From: Michael Eastham
Sent: 11 December 2020 10:32
To: Planning Scanning
Subject: FW: A/166/20/DOC - Manor Nursery, High Street, Angmering

Please see the email below which is the consultation response from the ADC Drainage Engineers to discharge of condition application **A/166/20/DOC** relating to Manor Nursery, High Street, Angmering.

1. The impermeable areas plan supplied does not clearly show the areas draining to each soakaway. E.g. the areas draining to soakaways 8 and 9 are poorly defined. Please can the applicant supply a better impermeable areas plan which clearly shows the areas draining to each soakaway and which areas have had 10% urban creep allowance applied. 60_Network Areas Plan has now been updated for clarity and the drainage areas for SA 8 and 9 is now more clearly defined. The plan also now shows which areas have Urban Creep of 10% applied to them in the key.

TYPICAL WAVIN AQUACELL SOAKAWAY DETAIL
(Scale 1:20)

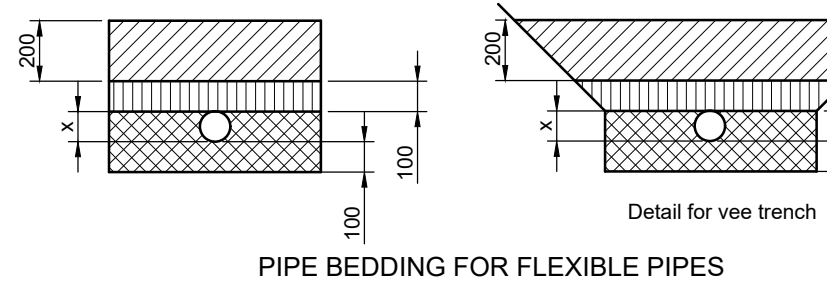
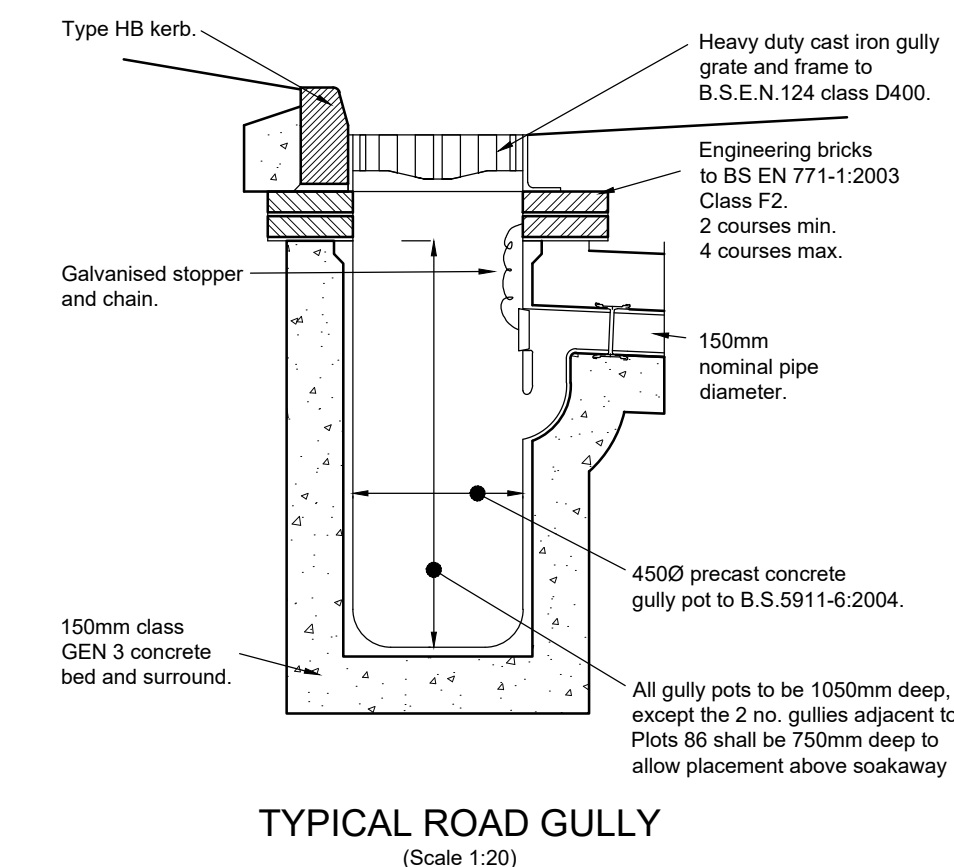
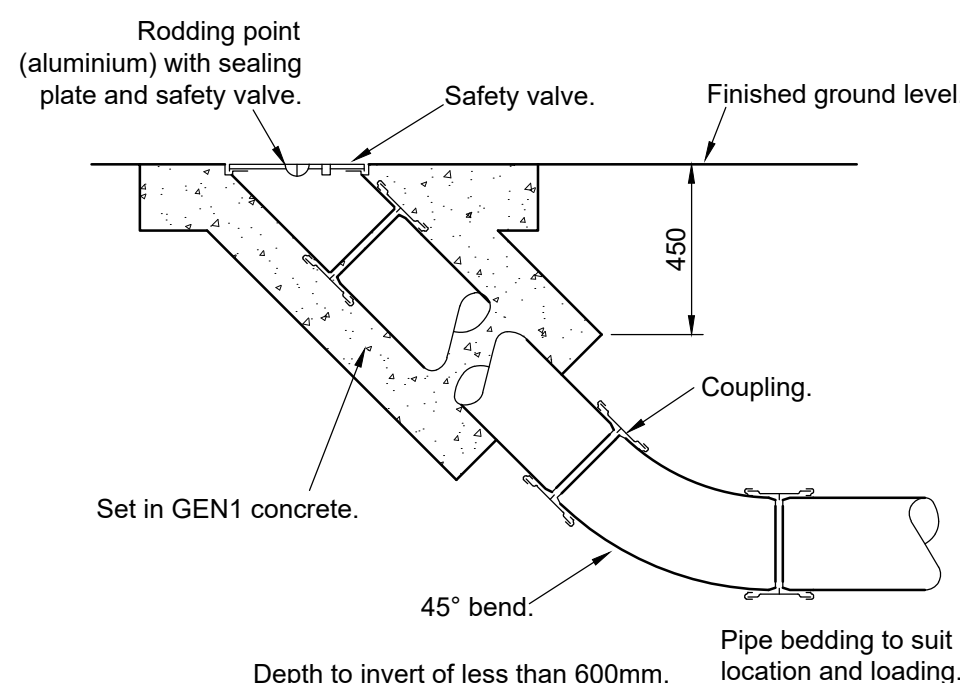
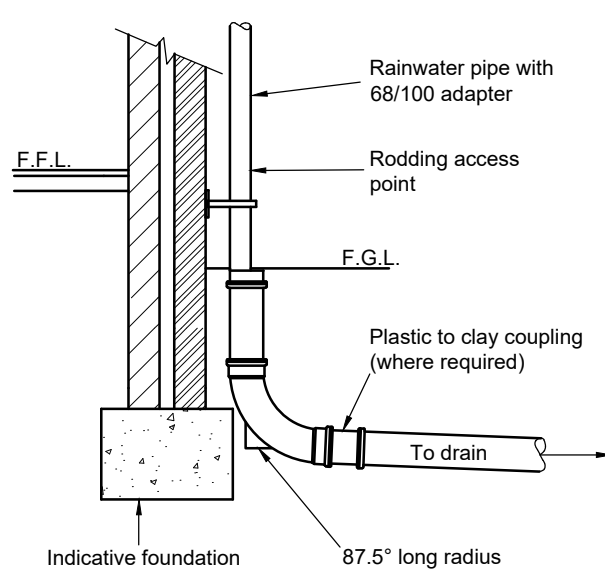
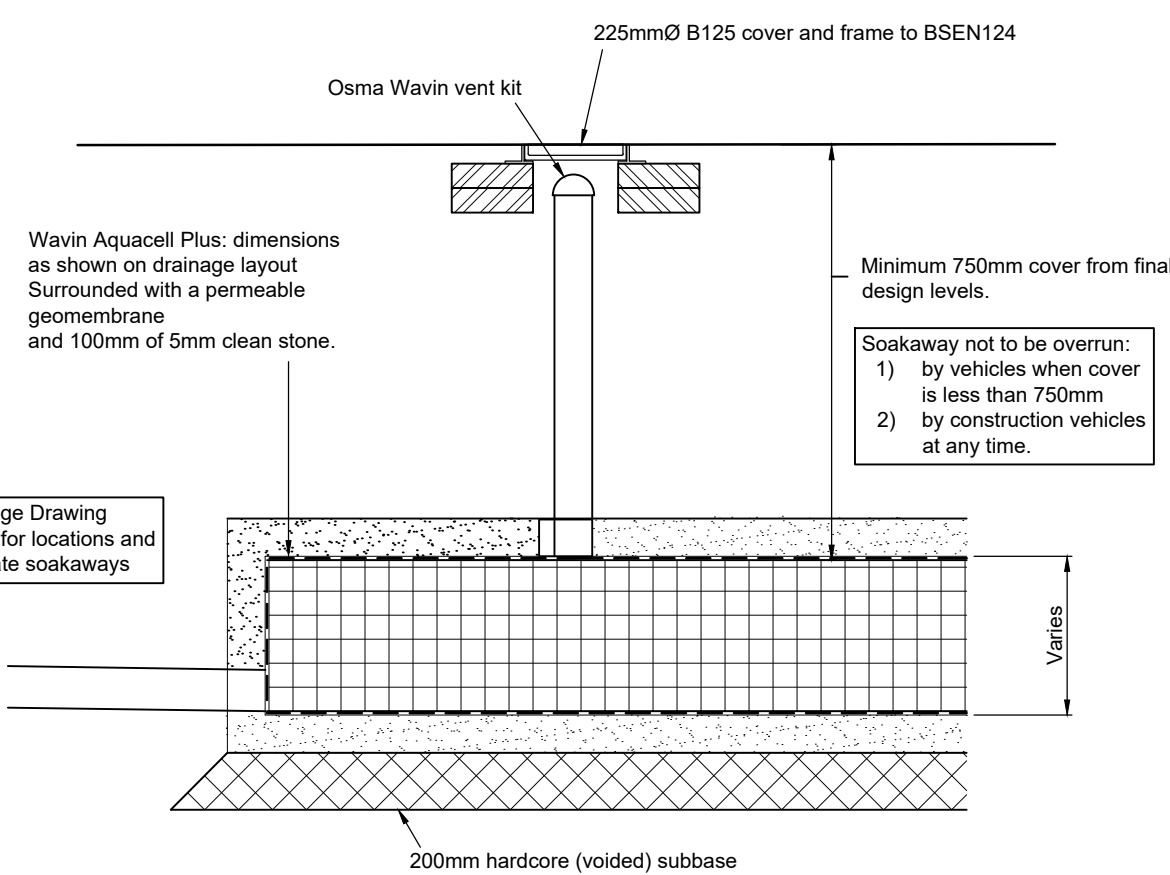
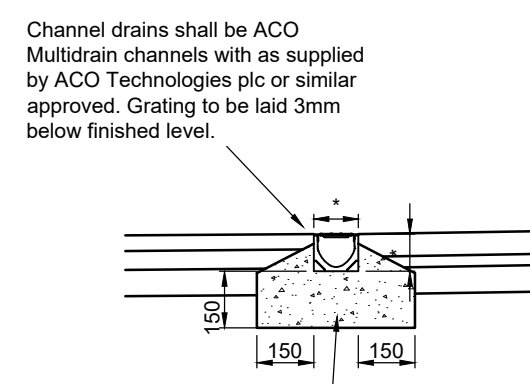
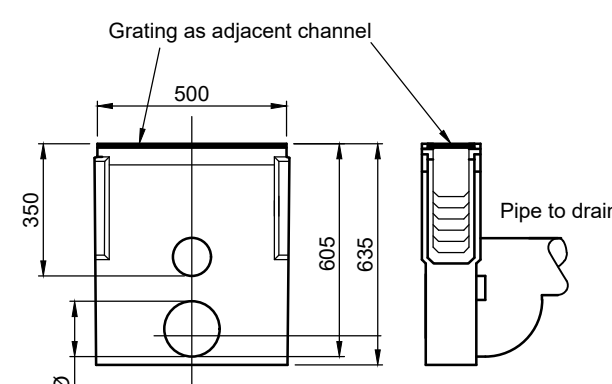
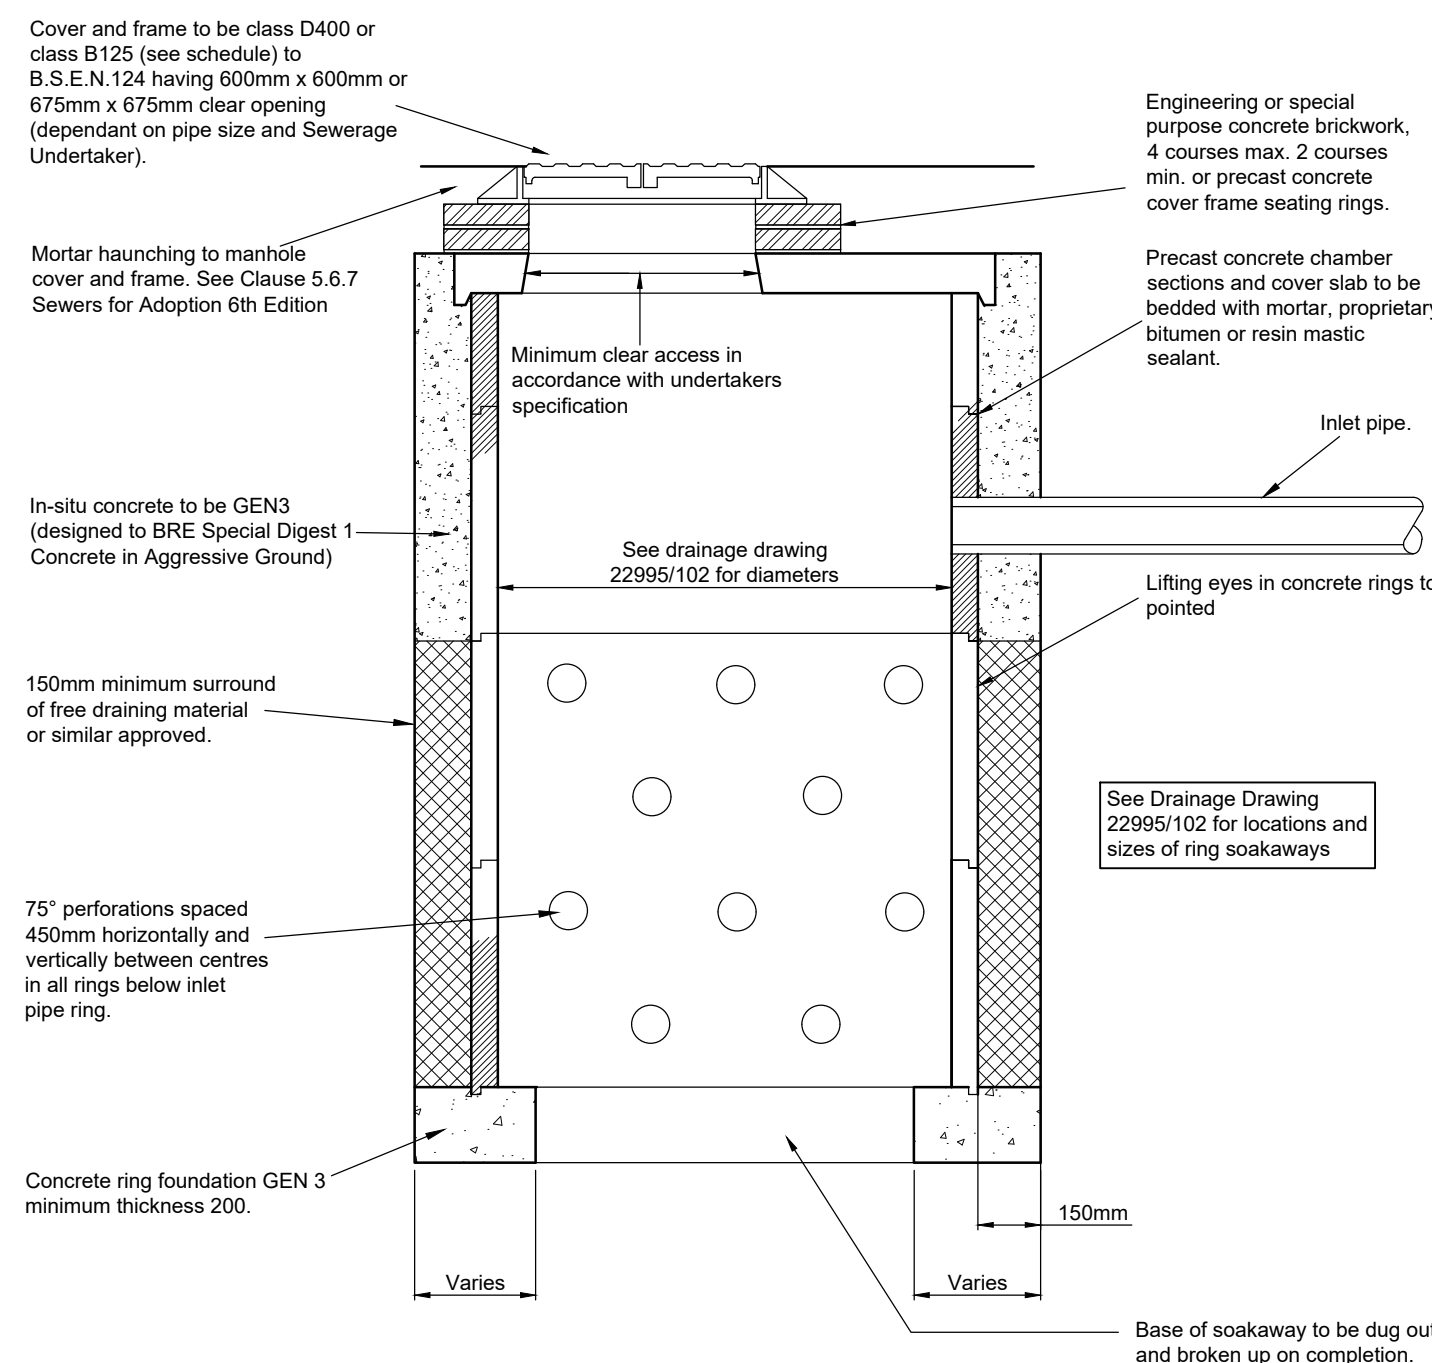
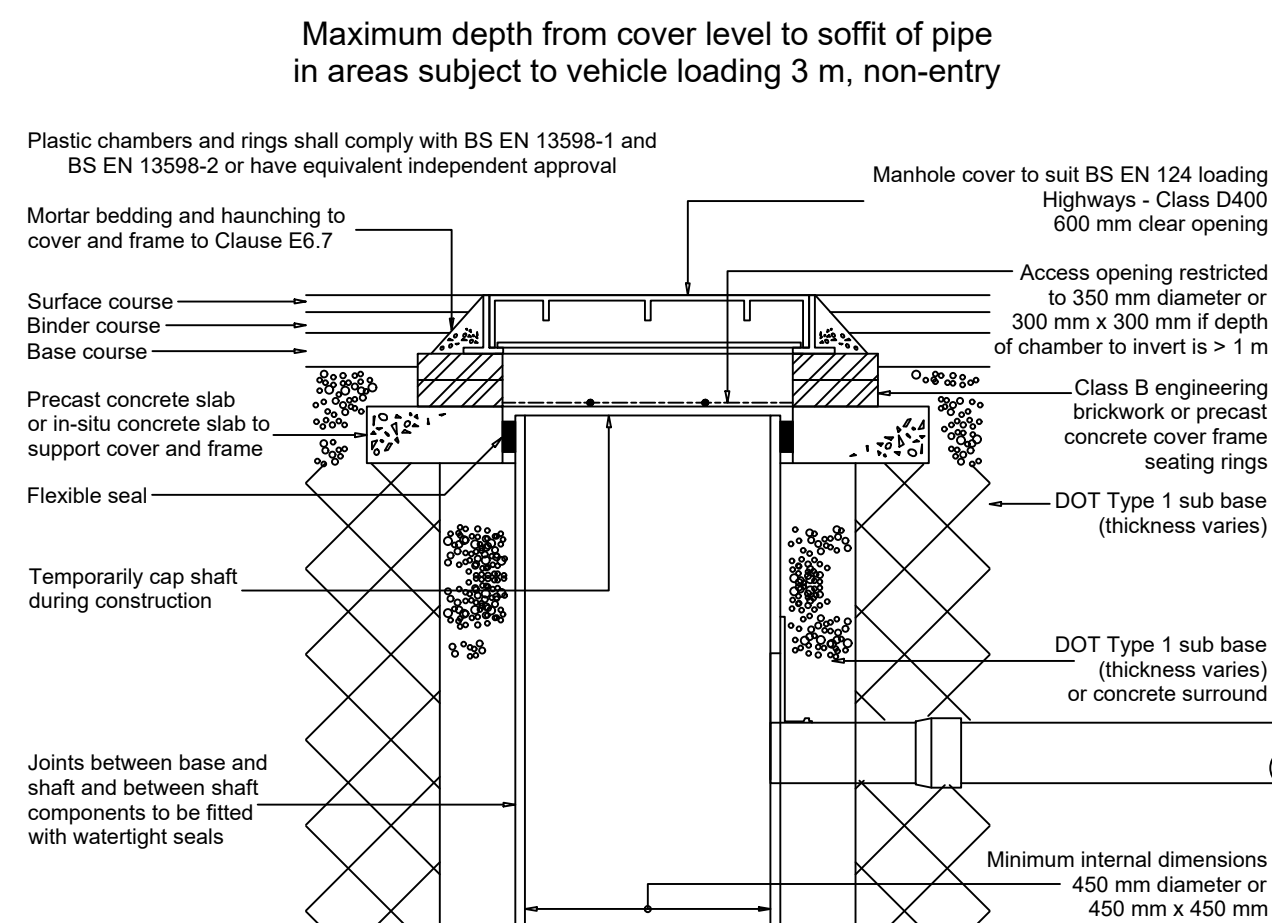
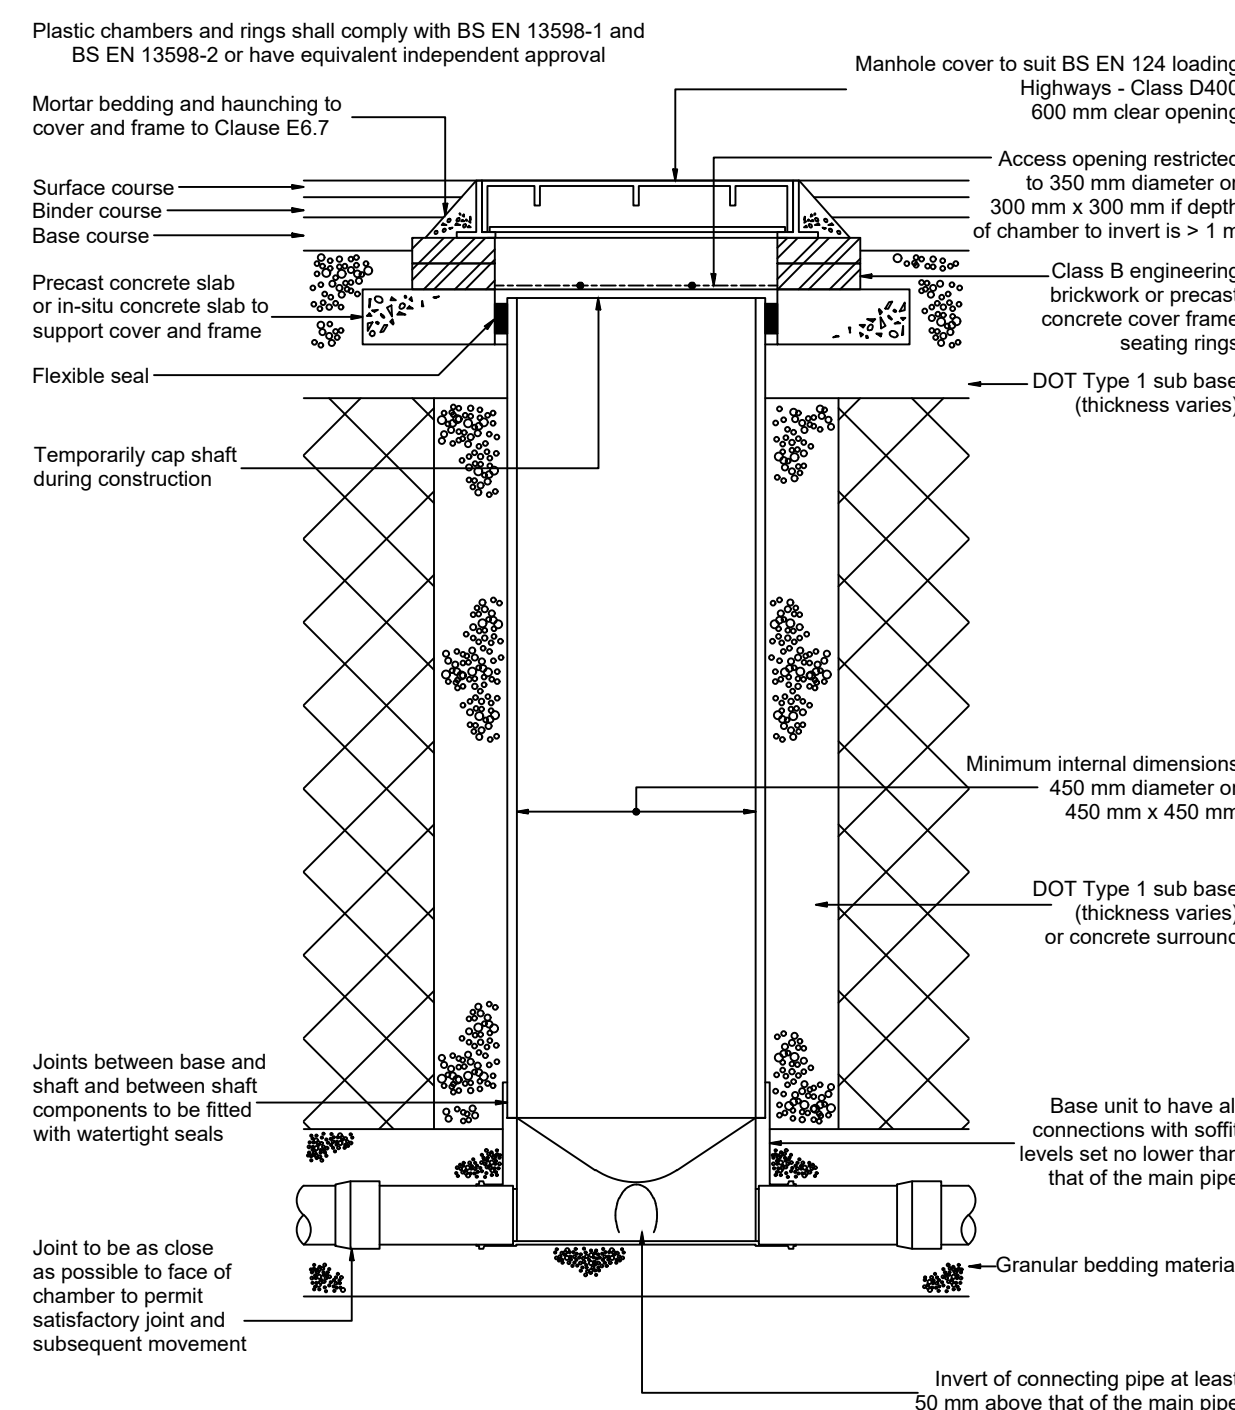
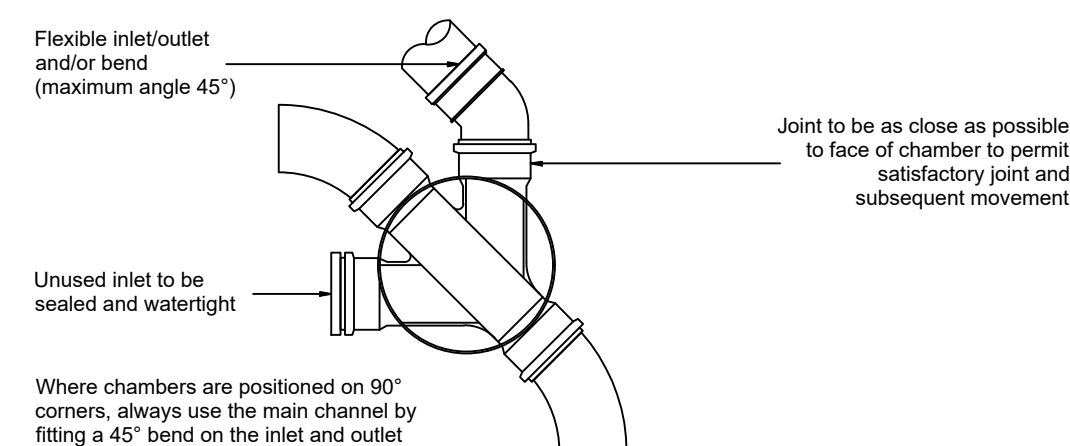
8. The calculation details for SA 7, SA8, and SA9 are different to those on plan. Please correct so that they are consistent. Calculations updated.
9. Construction detail drawings need to be provided, as per our checklist. Please see 502_Construction Details.
